From: David Glover [REDACTED]
Sent: 27 July 2021 15:09
To: Neil Crowther <Neil.Crowther@arun.gov.uk>
[REDACTED]
Subject: RE: : PLANNING APPLICATION REF:EP/56/21/HH

RE: PLANNING APPLICATION REF:EP/56/21/HH

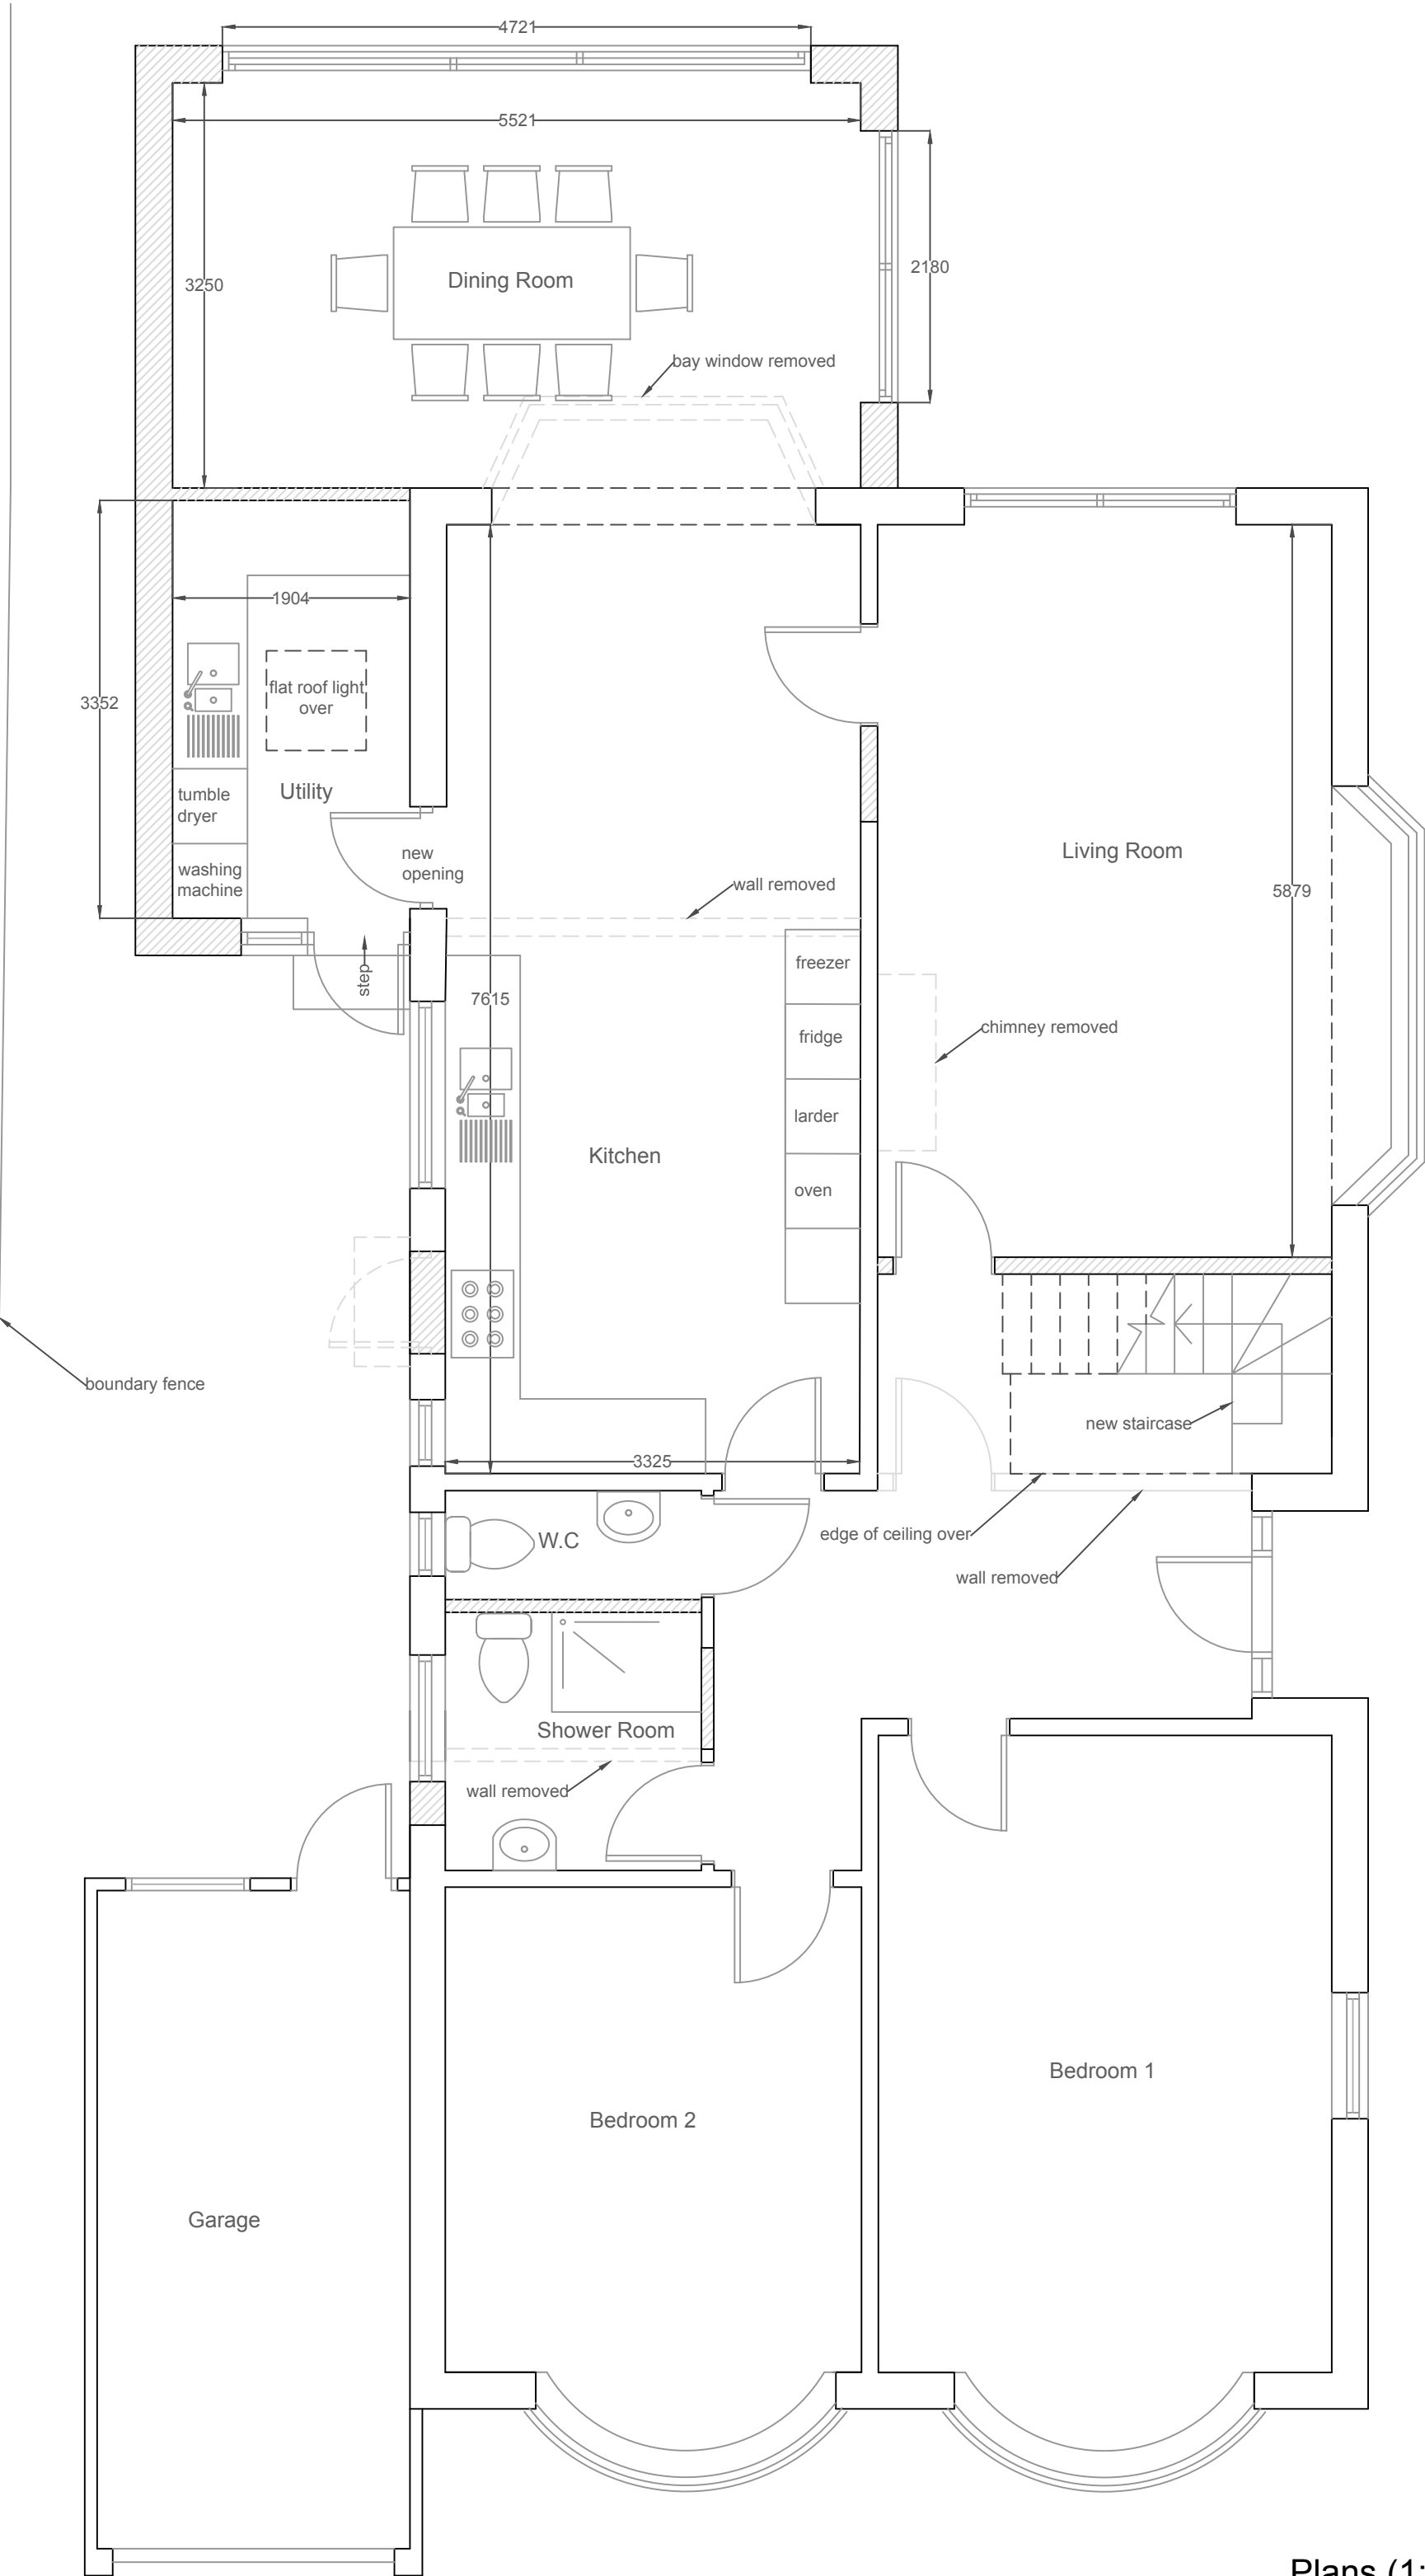
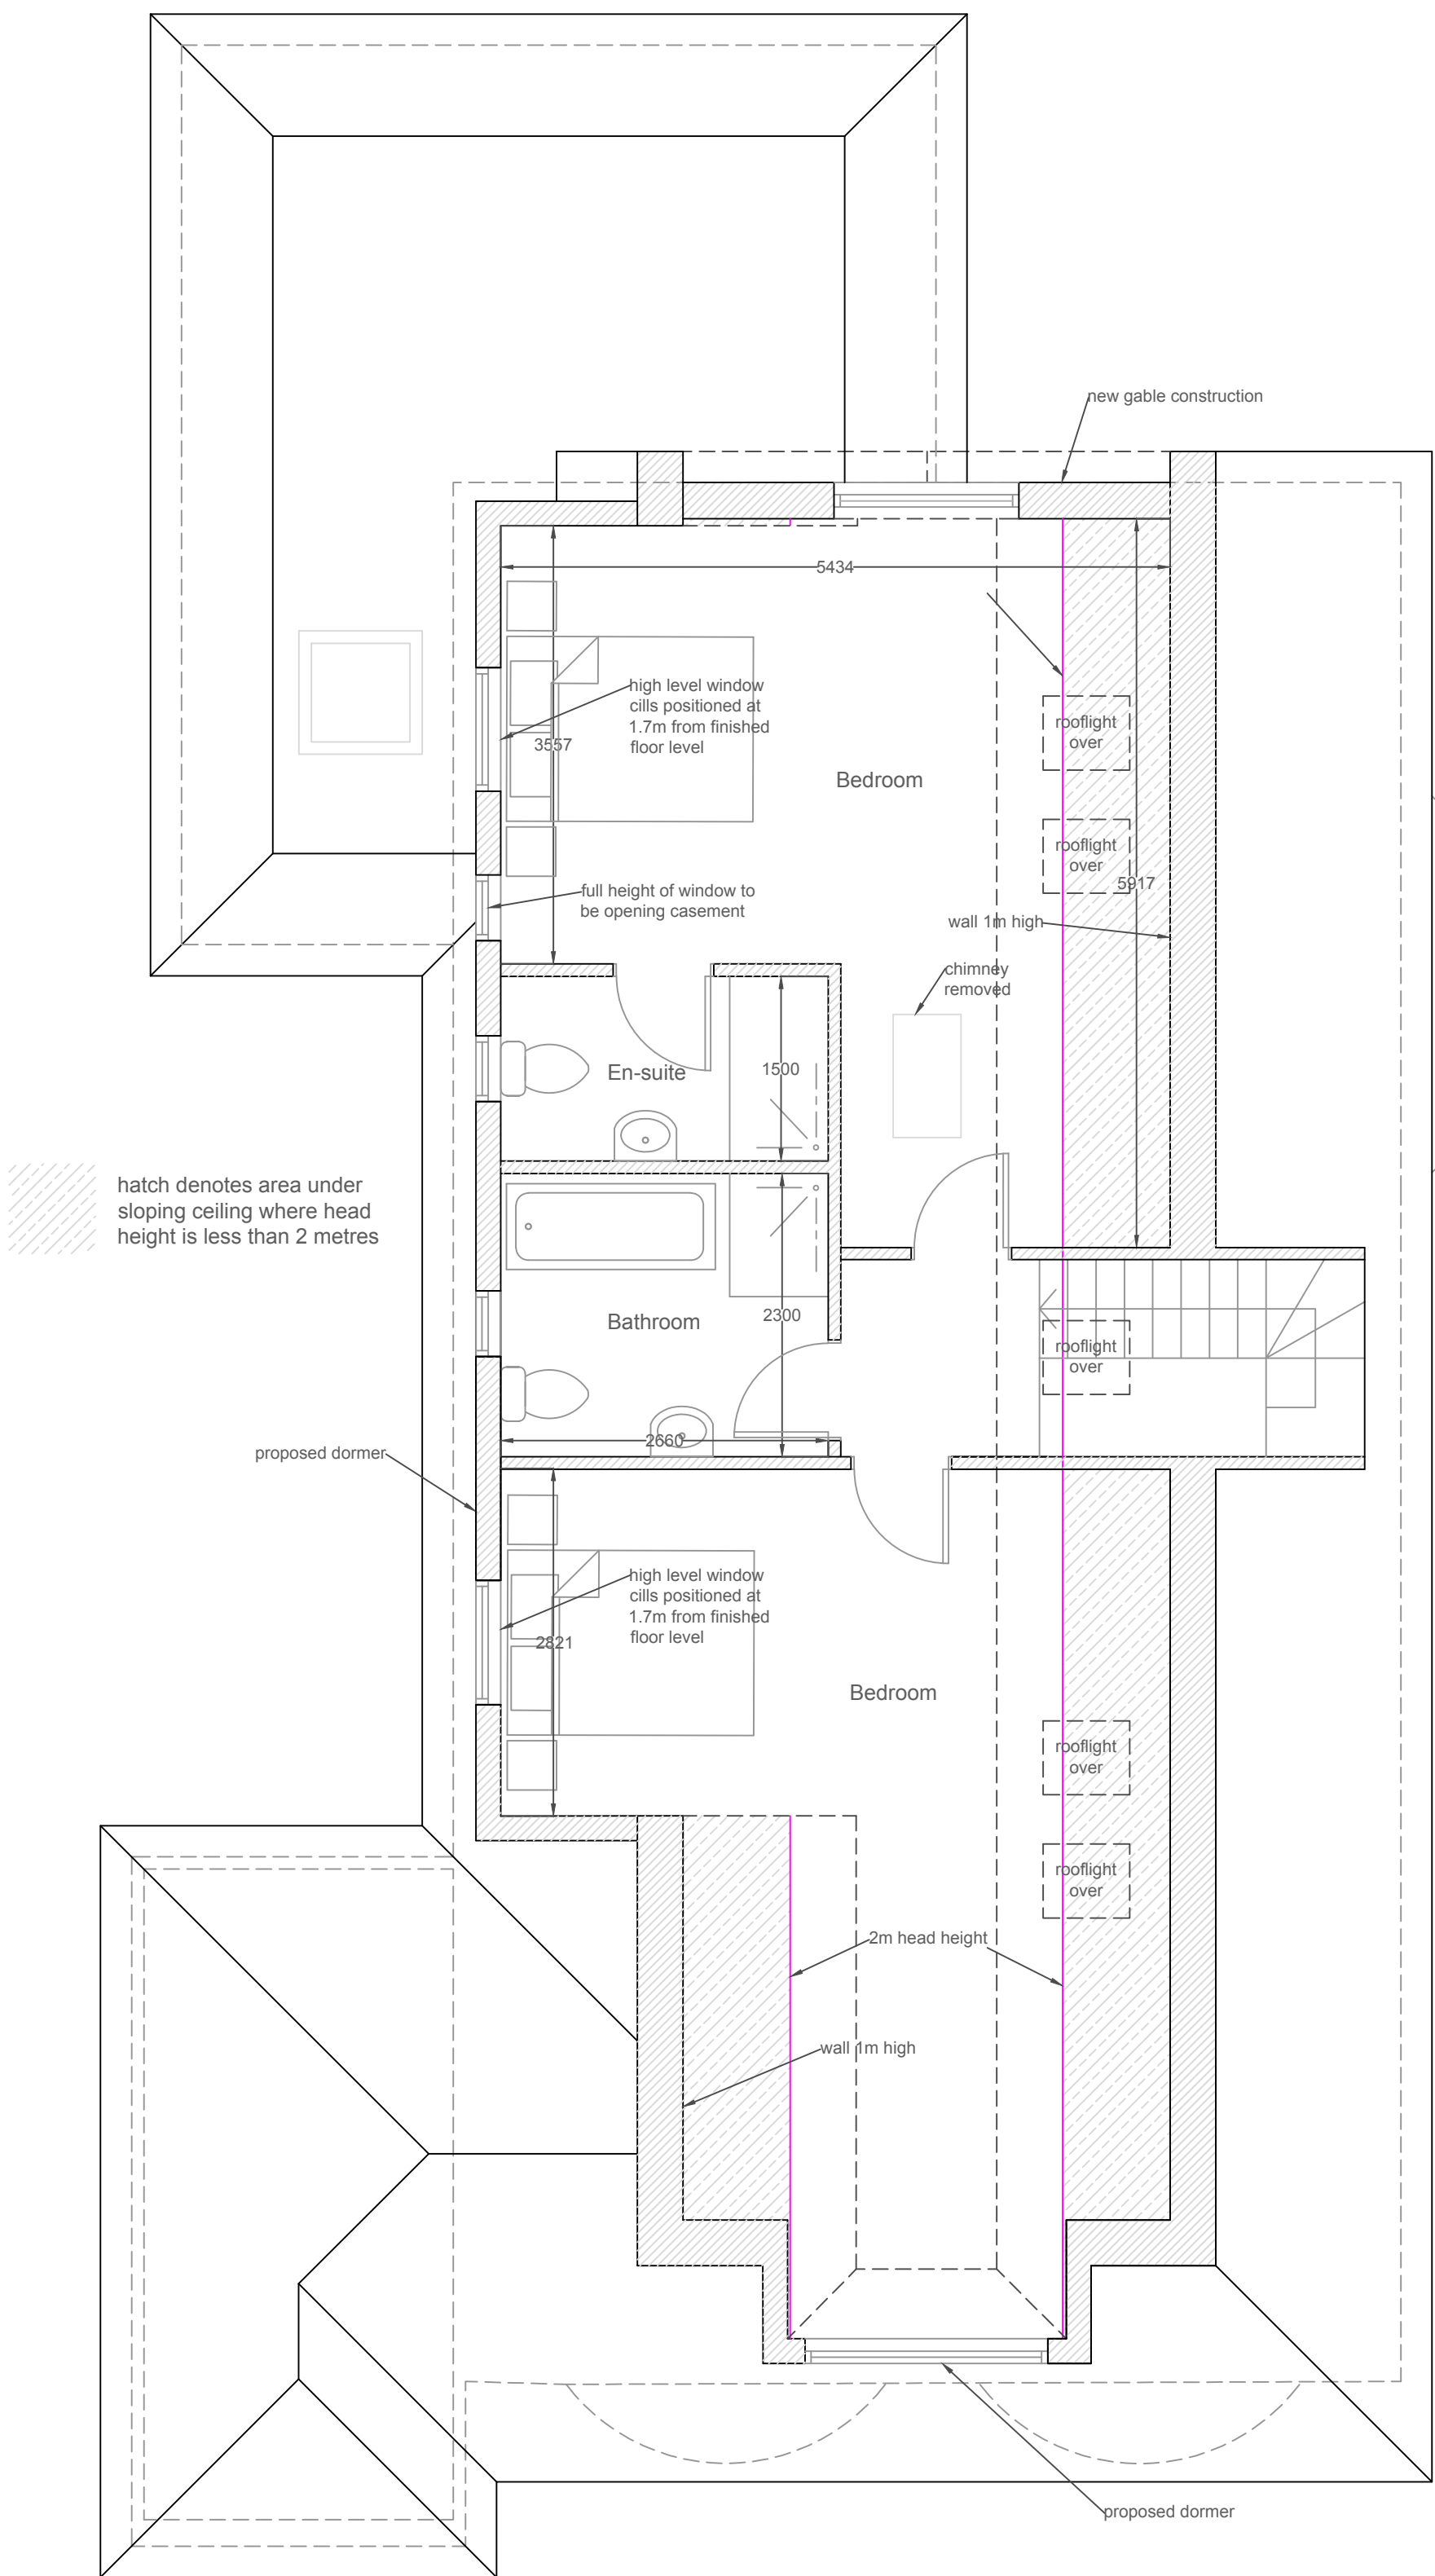
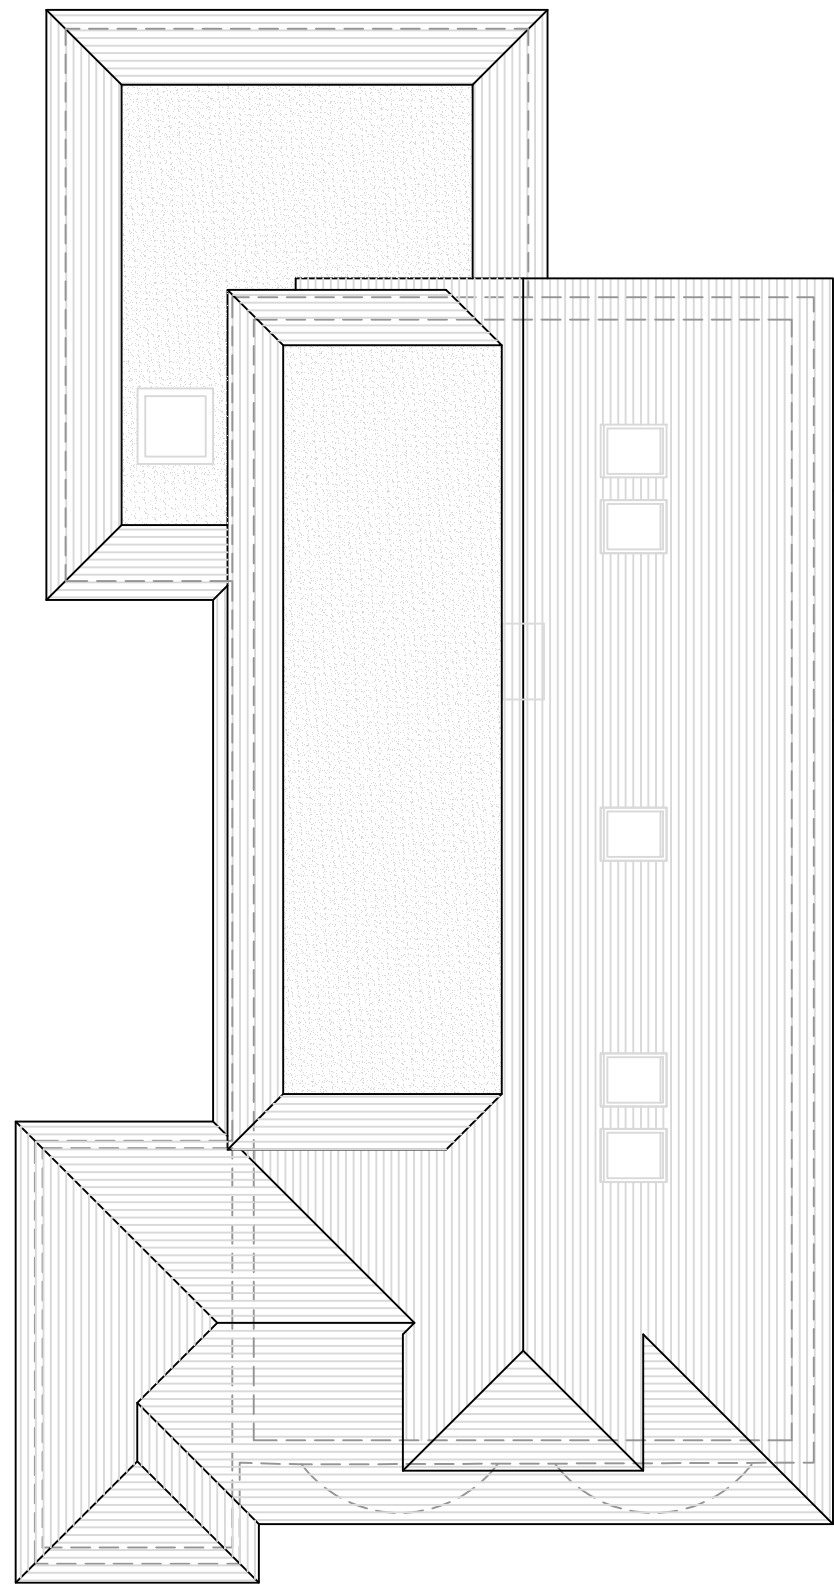
- 1) You say "what was proposed could pretty much be permitted development" and yet you accepted and acted upon it as a Planning Application. So what do you mean precisely?
- 2) "The only restriction on such a development is that windows are 1.7m above floor level", can you confirm that this is the case for all the windows as shown on proposed plan 1281.02.d?

I have managed to read the decision, made by the Council, but cannot understand the decision-making process that has been applied to the proposed Northern elevation. The opening casement window, and indeed all windows to this side of the property do not conform to the Council's own requirements. This could be considered overdevelopment of the plot as highlighted by East Preston Parish Council.

Returning to our privacy concerns. As stated in our objection, the distance from our Southern Boundary is approx. 82cm. Surely this proximity should have been considered at the decision-making process. Was it? It would seem that "a full height opening casement window" (as stated on plan) to be "completely obscurely glazed" would not be obscured in any way, shape, or form when open! This window would directly overlook my principal living space, both home and garden. This decision makes no sense at all. Perhaps you would care to comment on the rationale behind it?

When determining applications we have to consider the requirements of planning policy as well as what could be built as permitted development – that is development that could take place without the need for any planning permission from the Council. In this case, a large box dormer window on the side elevation

of a property could be built without the need for planning permission. The only restriction on such a development is that windows are 1.7m above floor level.
